December 30, 2014

**RE: Revised Grading Plan (C-17D122)
Kirkpatrick Warehouse
Albuquerque, New Mexico**

December 23, 2014

**Re: Kirkpatrick Warehouse
Kirkpatrick Warehouse Drainage Report with Engineer's Stamp dated 11-25-14
Kirkpatrick Grading and Drainage Plan with Engineer's Stamp Dated 12-22-14
(C17D122)**

DC-780 ISOLATOR ROW DETAIL  
NTS

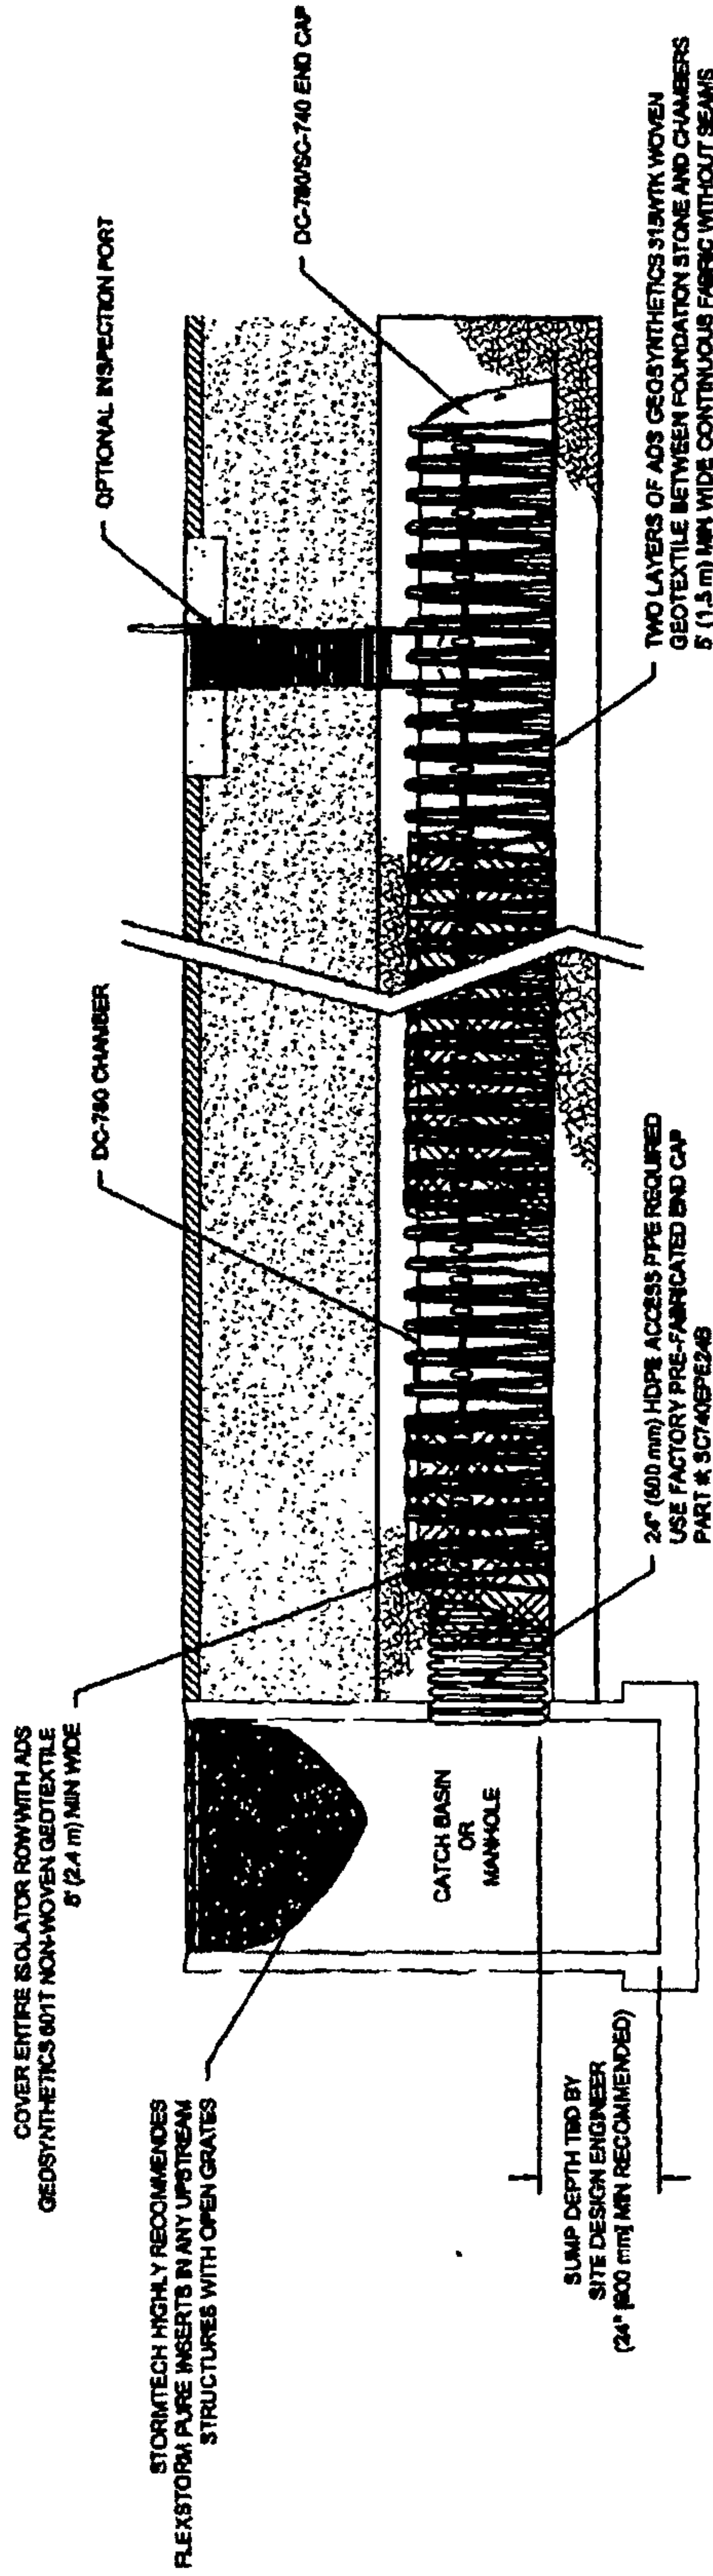
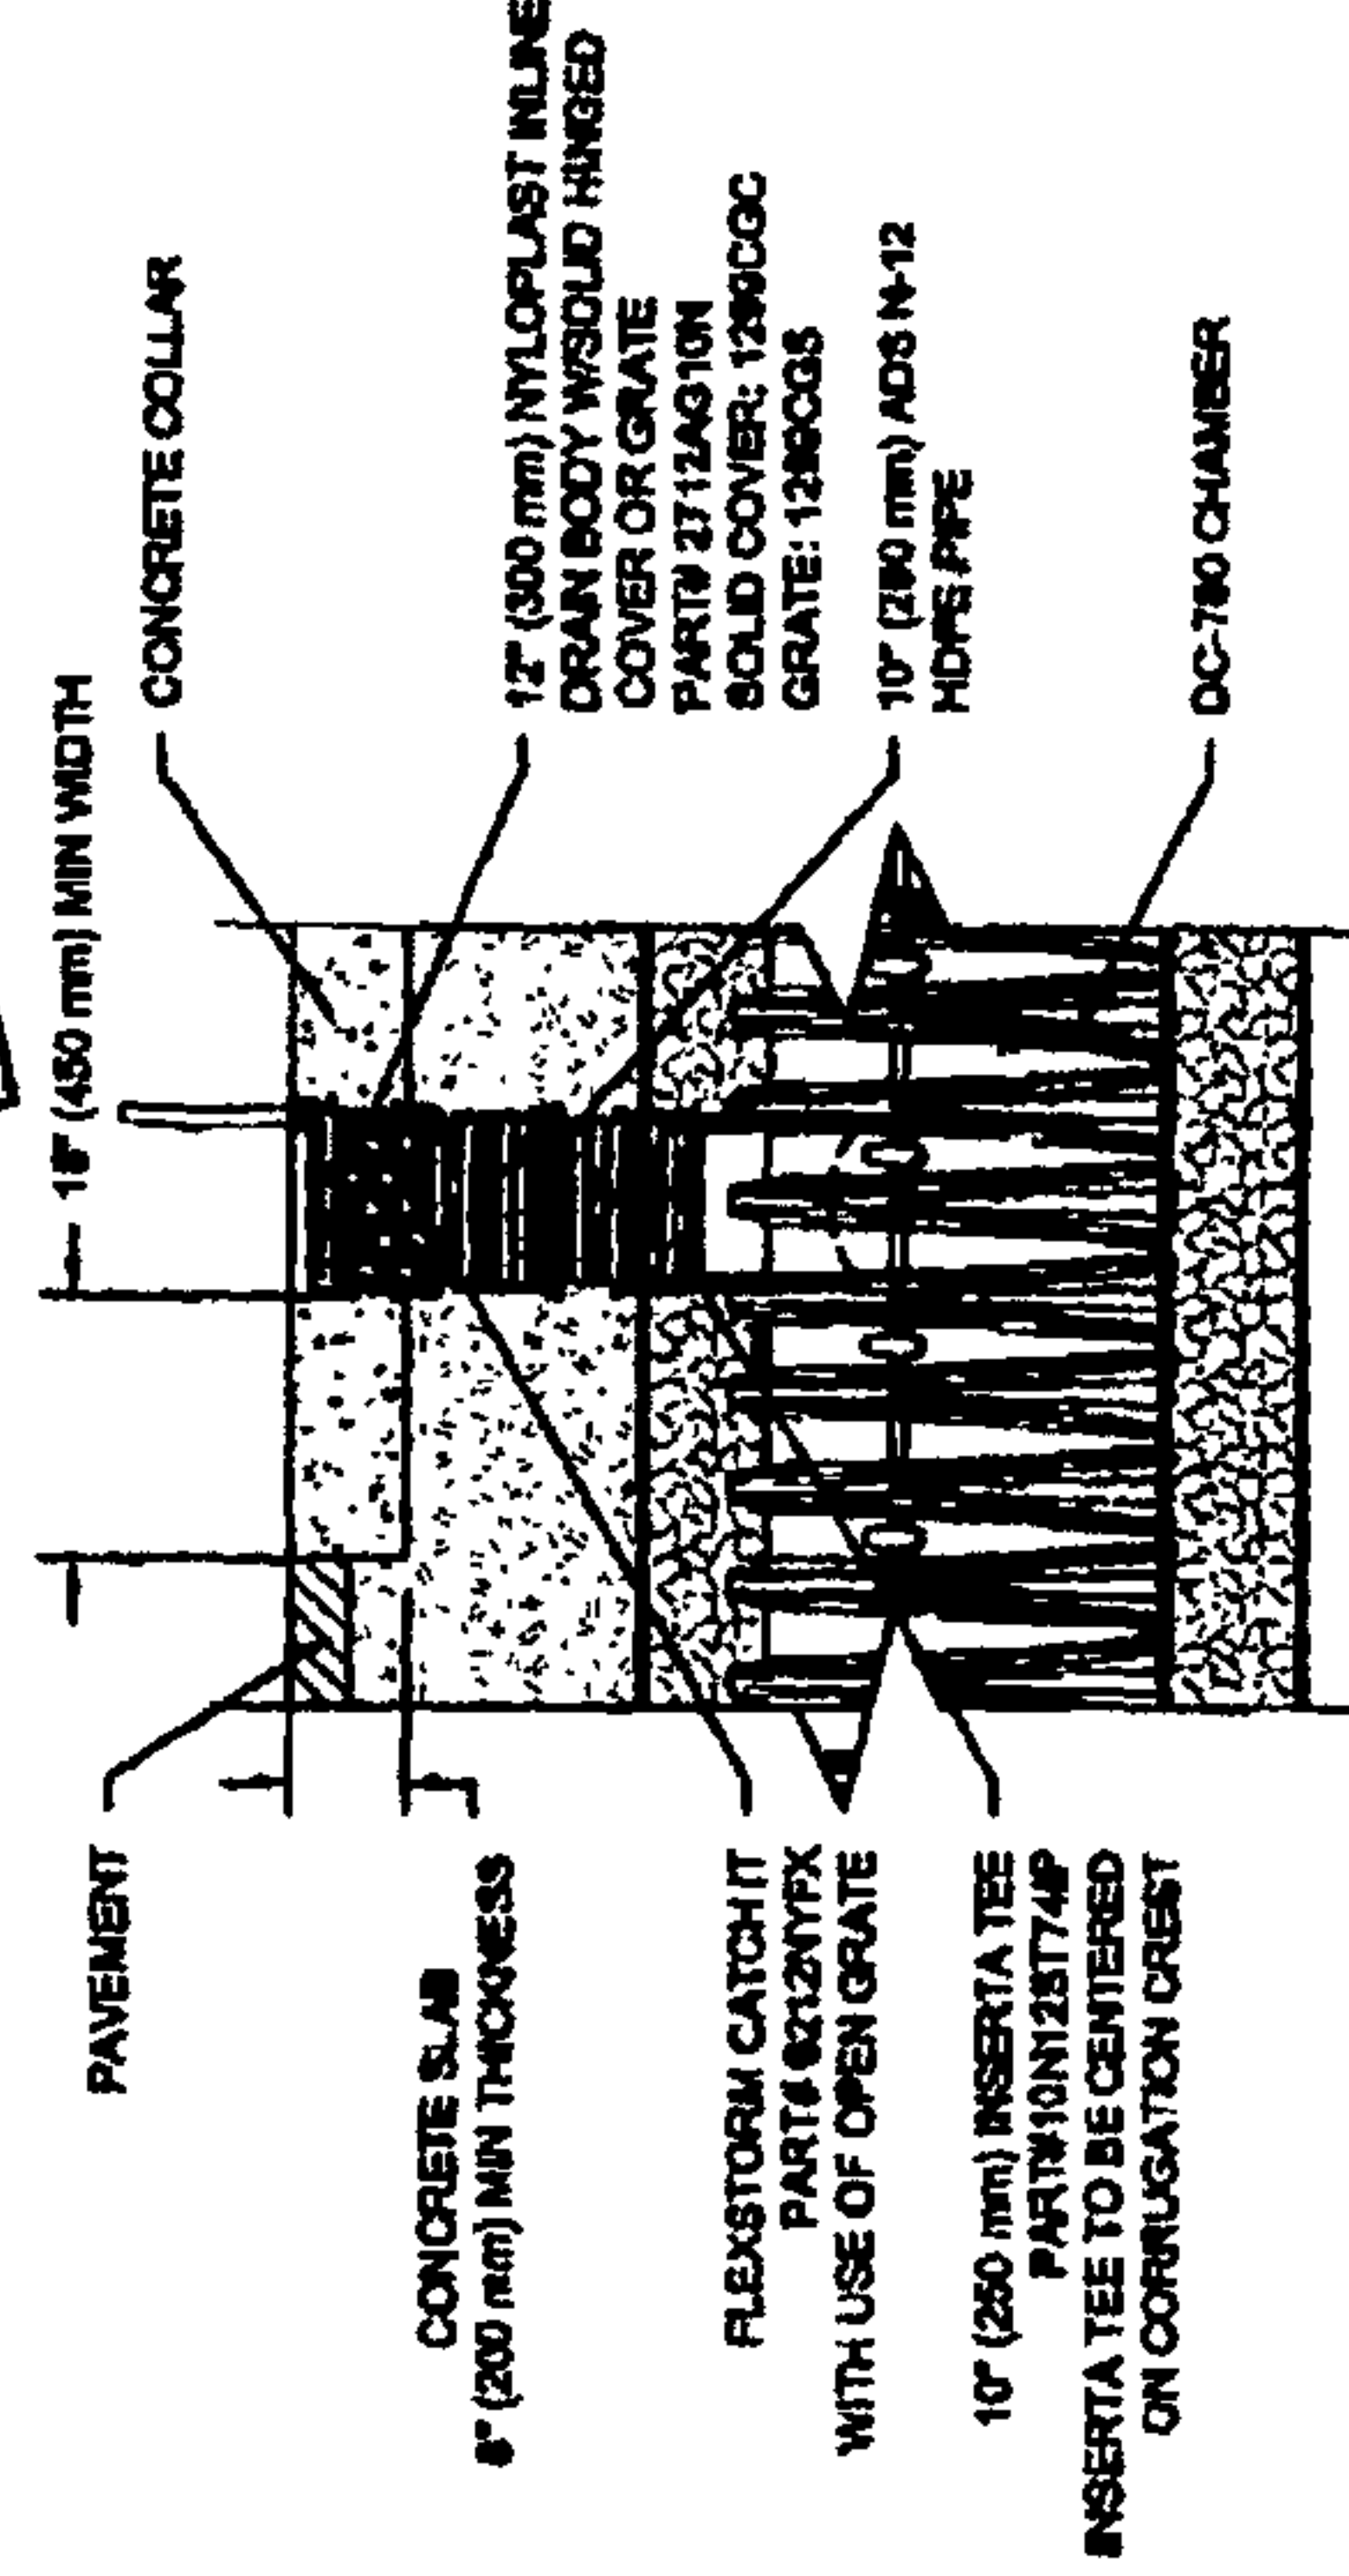
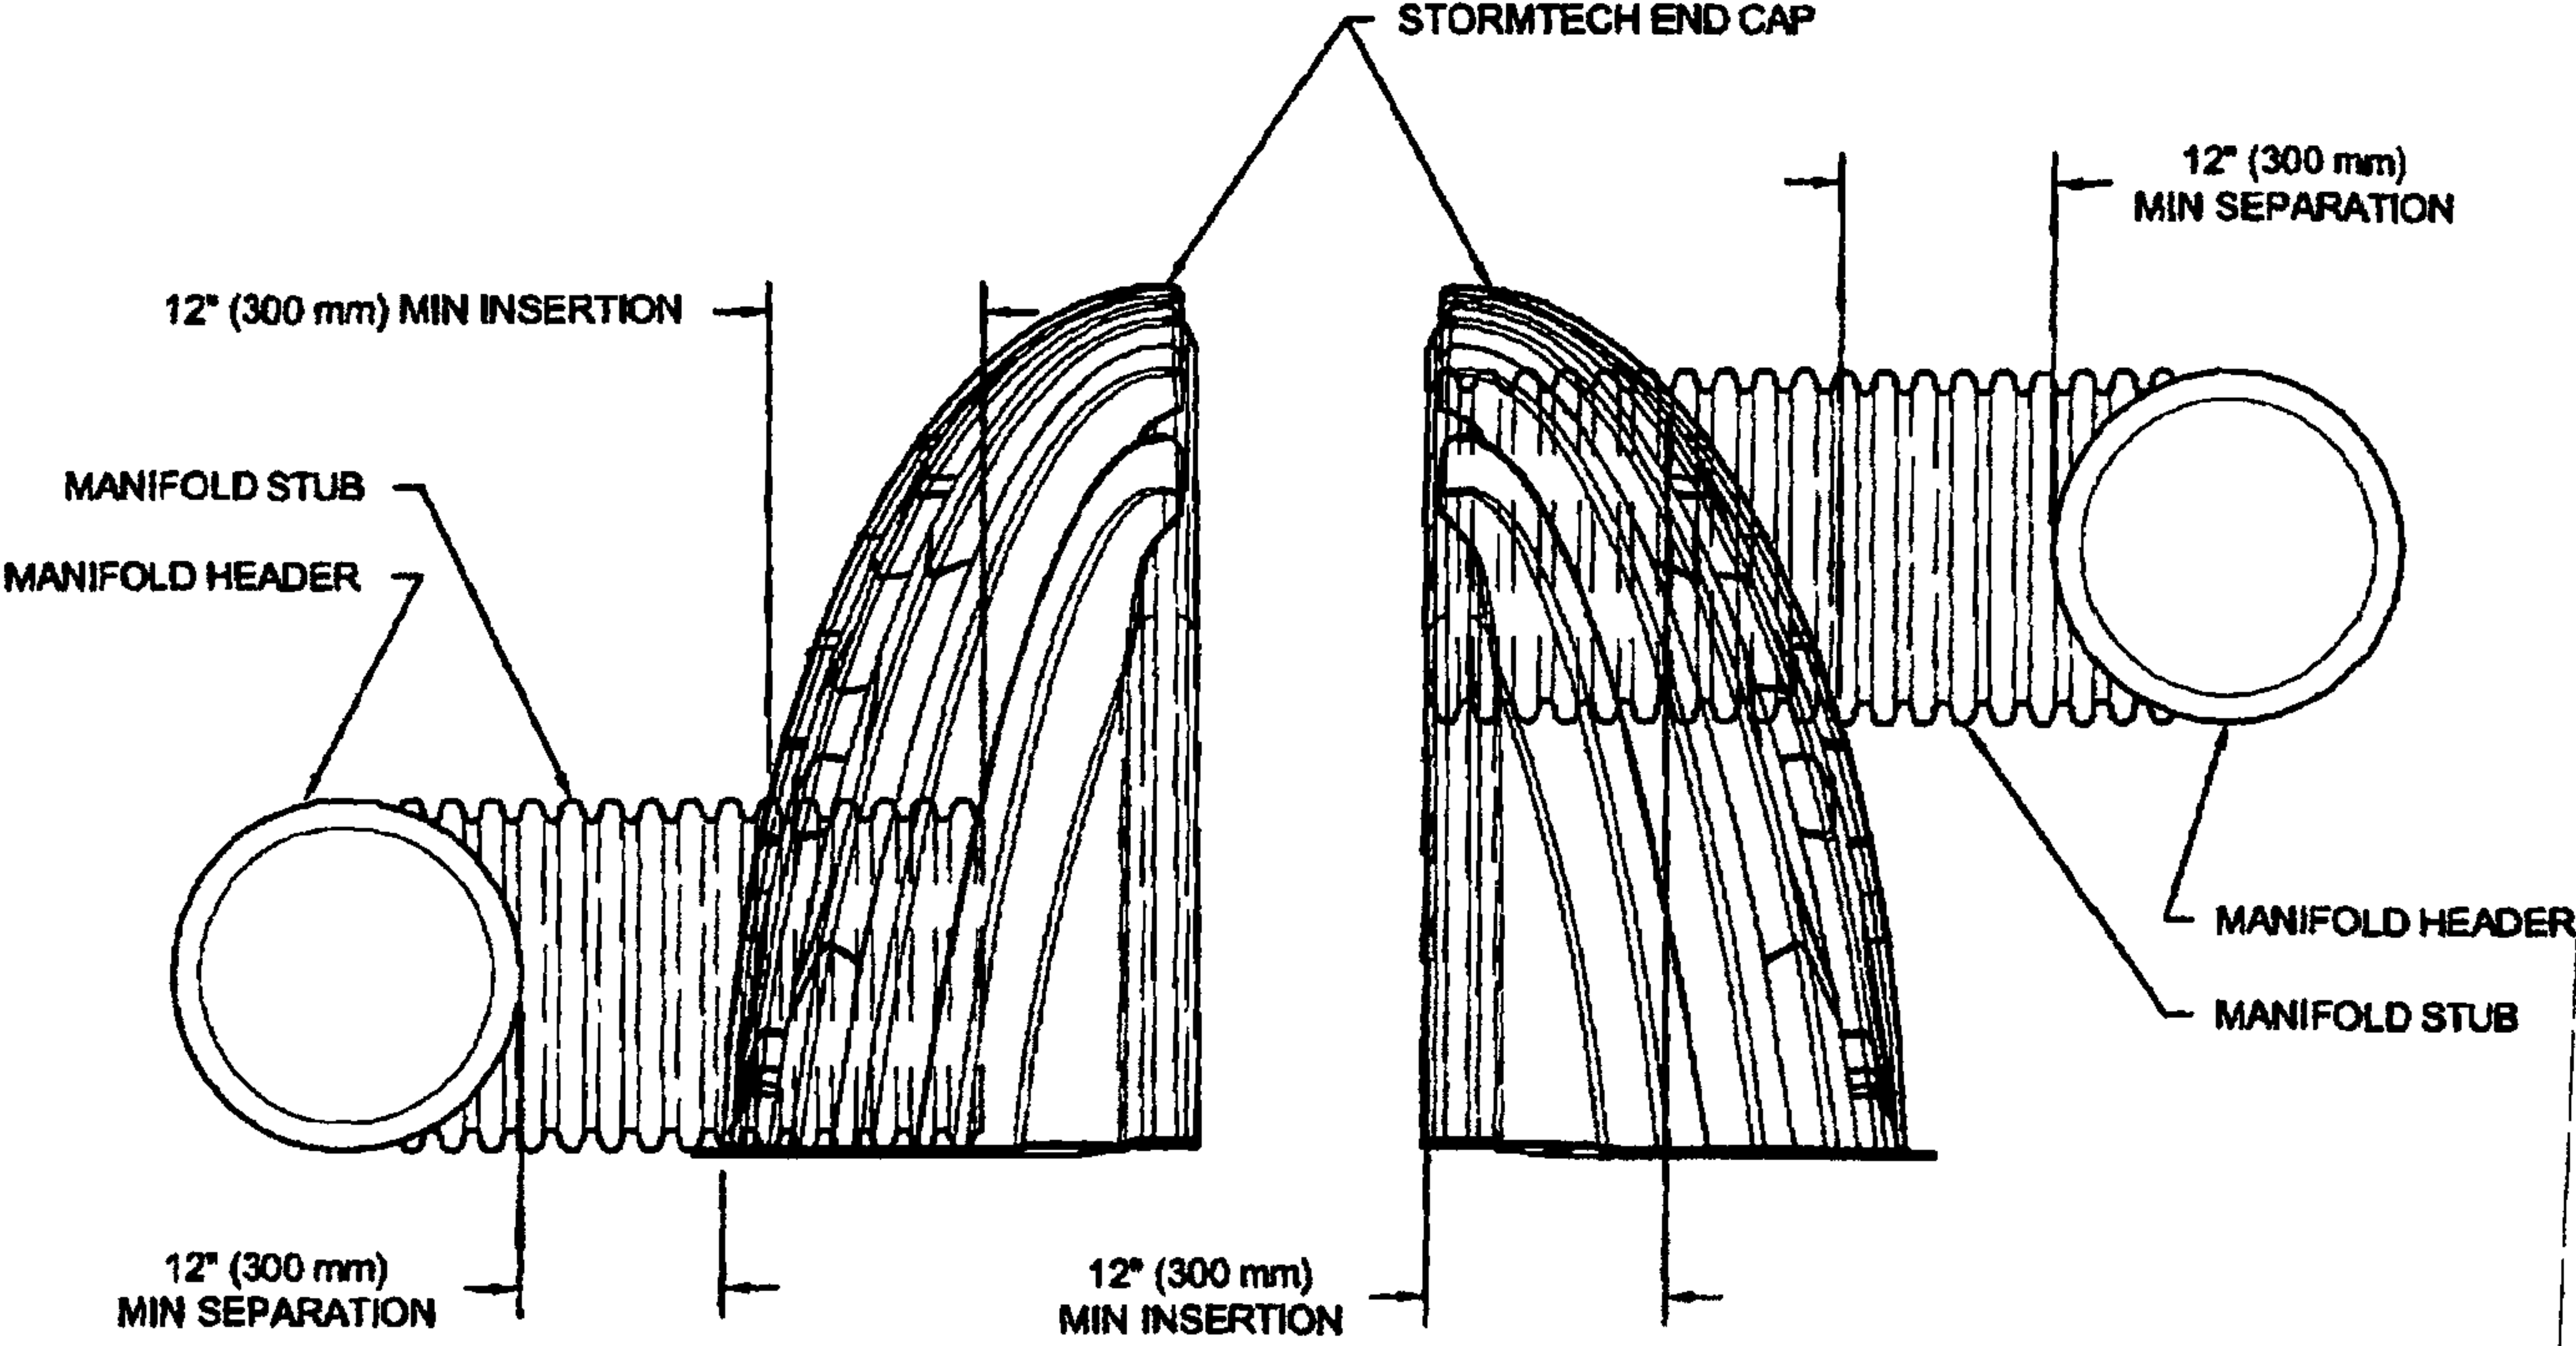
4. Specify manifold, and separation, how is system to be cleaned

1. Include calculations for the design of the Stormtech system.
2. Provide a detail sheet for the Stormtech system that includes plan and profile views.
3. The inlet grate is at 94.25 but the invert is at 59.75. What should the invert really be at?
4. How will the manifold system be set up? How far apart are the rows? How will flows go into the isolator row? How will the isolator row be maintained and cleared of debris?
5. You have specified S780. Do you mean DC-780? What stub are you specifying?
6. What are the depths and type of stone for the whole system?
7. What kind of geotextile is being used? Where is the fabric located?

We have better shown how the manifold works, the inlet is an inline basin each leg of the inlet drains to a reach of the system. The details show the separation of 6". We have added inspection ports which are used for maintenance. A vactor truck is used for periodic maintenance.
